From: [REDACTED]
Sent: 17 January 2018 10:49
To: Simon Davis
Cc: 'Castle'; 'Phil Bell'; 'Chris Saunders'; 'Steven Shaw'
Subject: RE: BE/63/17/OUT, The Cottage, Shripney Road, Shripney - Road Accident 23rd January

Visibility and Access Arrangements

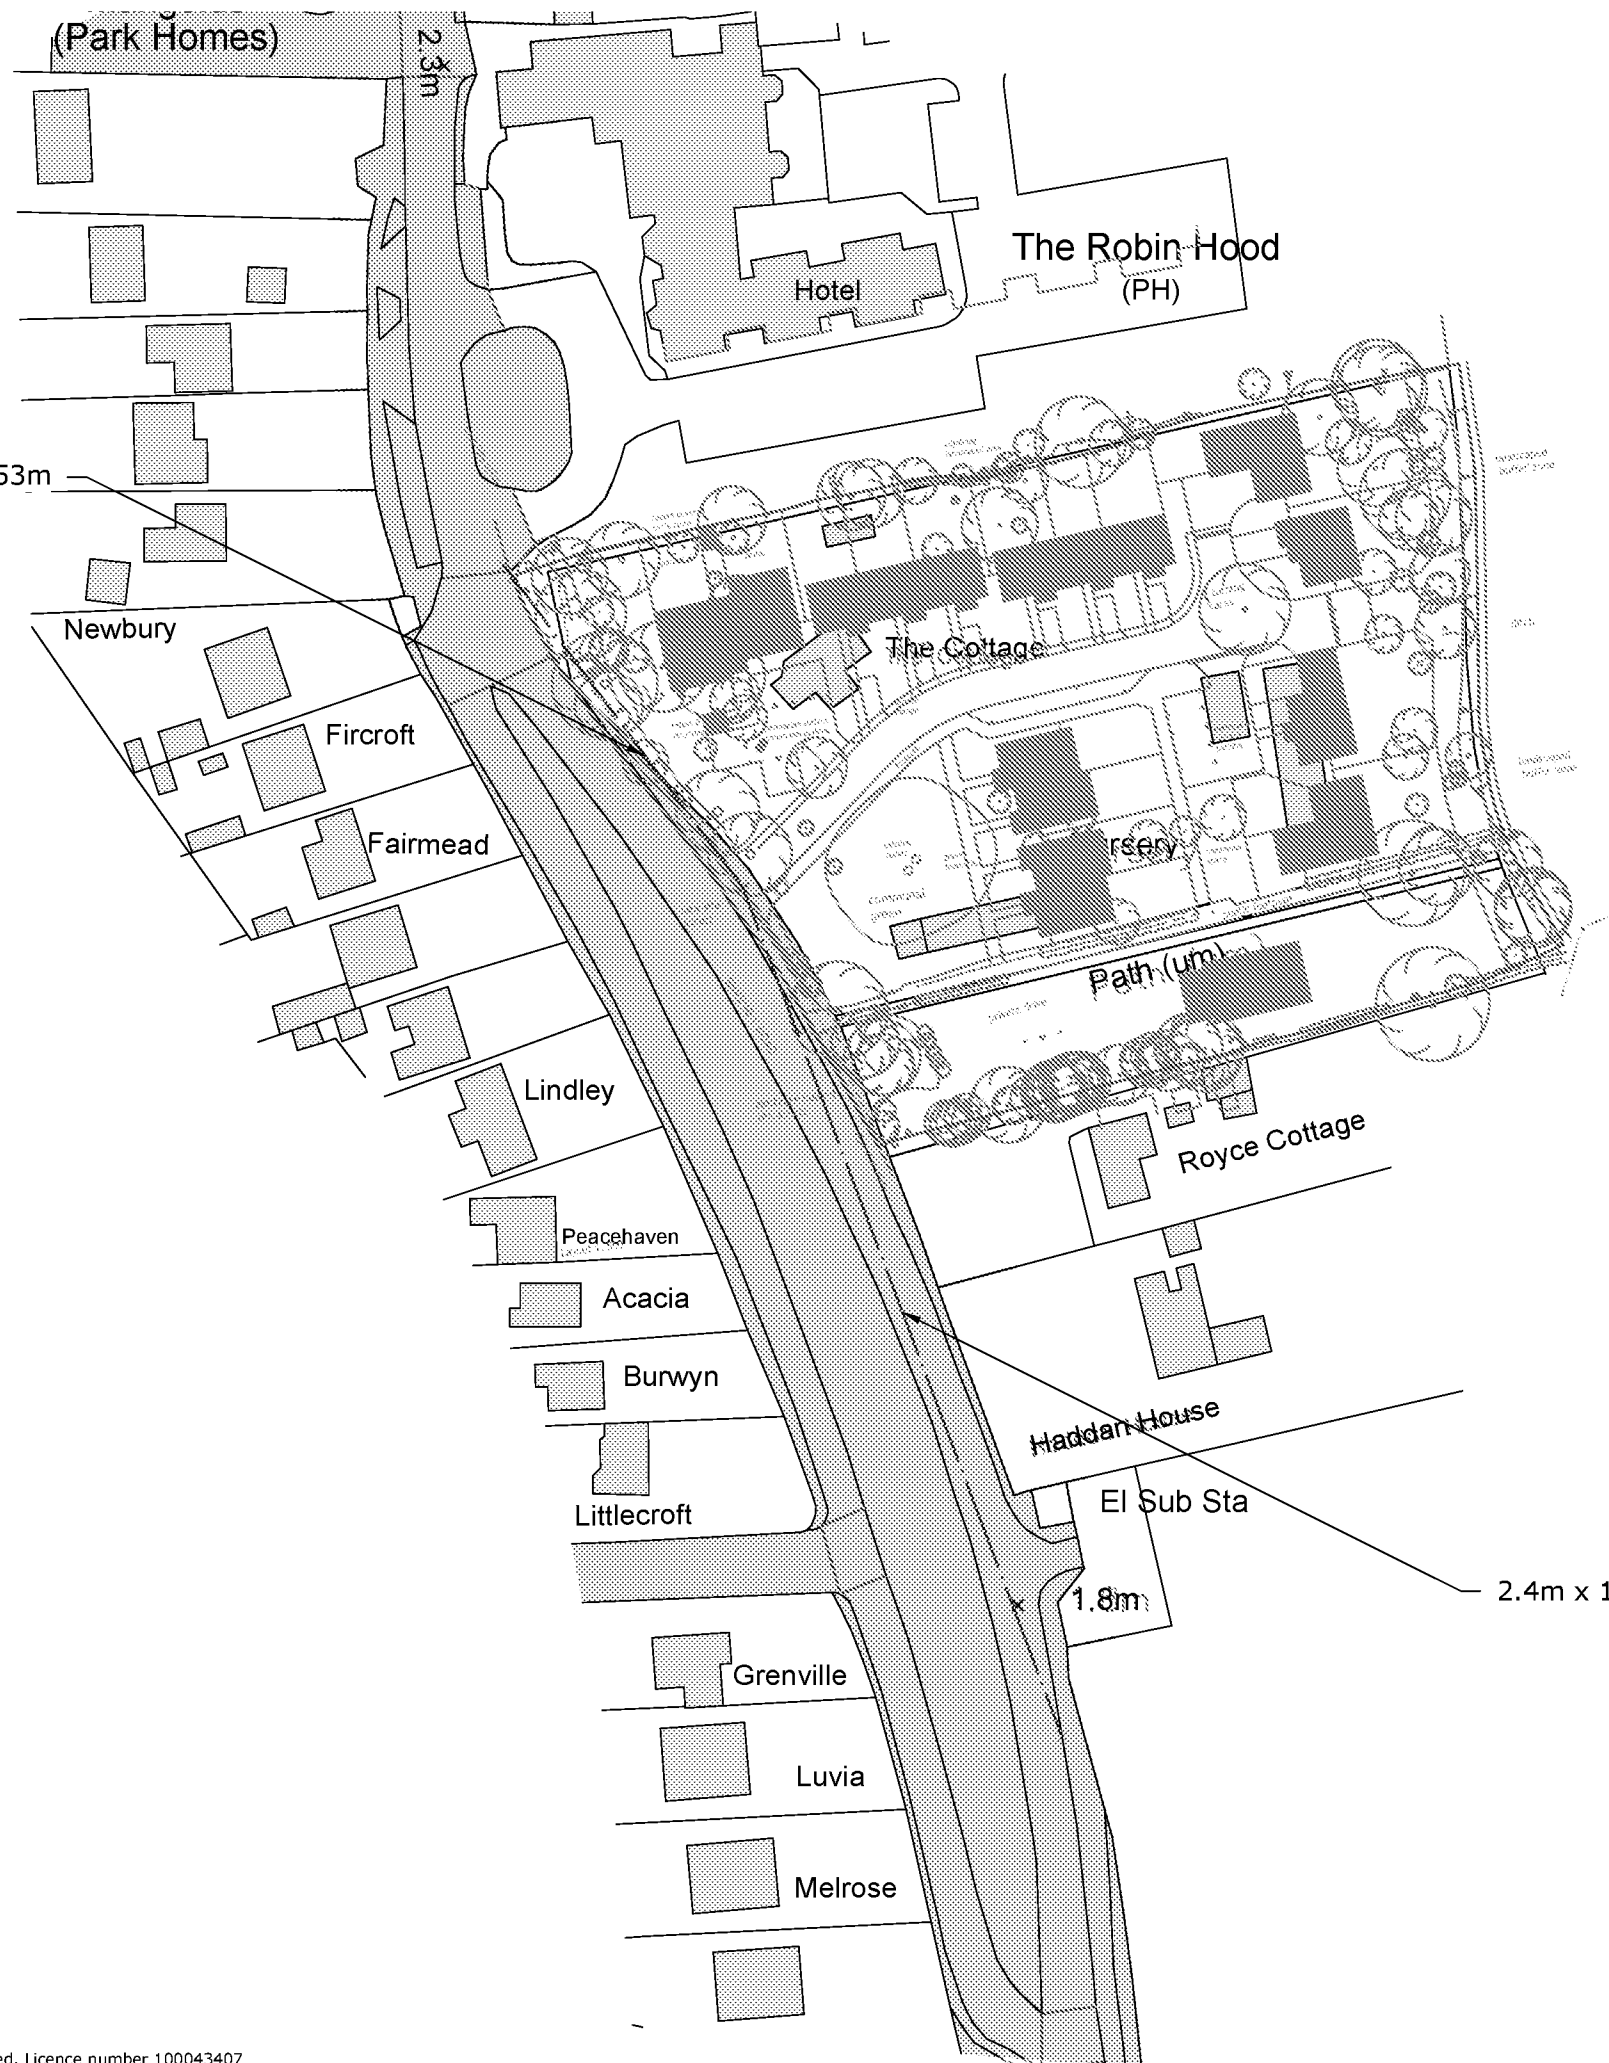
At the meeting Cllr Bower indicated that the application would be considered acceptable to members if the access were moved further to the south and if the pedestrian crossing point was removed from the scheme. They feel that this would give better northward visibility and would also mean that drivers exiting the site and turning left would not have to worry about people crossing the road as well as traffic coming from the north.

We previously examined the possibility of moving the access south by approximately 10 metres as part of the extensive design process that has been undertaken. However, we can confirm that this created a number of issues, including in relation to Highway, Public Rights of Way, and/or Tree perspective. Specifically these issues are:

- Moving the access any further south from its current location would affect the Cedar Trees at the front of the plot which are subject of a Tree Preservation Order (TPO);
- Moving the access further south would result in it being located adjacent to the existing access for the single dwelling, which would create highway safety problems; and,
- The existing Public Right of Way (PROW) would meet Shripney Road in the middle of the two accesses and may require a diversion.

With regards the Councillors' comments suggesting that that the pedestrian crossing point could be removed, we do not consider this to be a positive step in terms of accessibility or highway safety for future and existing residents on this eastern side of the A29/Shripney Road. The applicant's transport consultants, Motion, have commented that *"the crossing is a standard arrangement and the design complies with national requirements. In our professional view, removing it may hinder road safety as pedestrians will still have to cross the road to reach the footway provided along the service road and its provision will indicate to drivers that there is a pedestrian crossing point."*

As we presume Members had explained to them by WSCC Highways when they met on site earlier this month, and by yourself, the application proposals includes an agreed junction design, which provides acceptable levels of visibility, and which complies with all highway standards and policy requirements. Further the proposals would also

improve visibility for those exiting the adjacent Robin Hood PH, thereby offering betterment beyond the site boundaries.

With respect to the impact the access repositioning would have on protected trees, the applicant's tree consultant (Arbortrack) have confirmed that such a relocation of the access would likely bring it within the root protection area (RPA) of a mature sycamore (T35) that has recently been made the subject of TPO. In addition, this revision would require the driveway line to swing north into the site, which is very likely to result in an incursion into the RPA of a large cedar (T36) that is also subject to a TPO.

In summary, Motion, as leading transport consultants, have worked tirelessly with WSCC Highways to find the optimum access position and design. We are in a position where the Highways Authority entirely support our proposals – and indeed Mr Shaw's email to you of this morning confirms their support for our response to the Councillors' request. Given that access is included as a matter for determination as part of this Outline application, this is an issue that cannot be dealt with at the later Reserved Matters application stage, or via a condition. We therefore genuinely hope that the Councillors will appreciate why, having consulted widely on their proposals and tried our best to accommodate their input, that we feel the access is most appropriately left in situ.
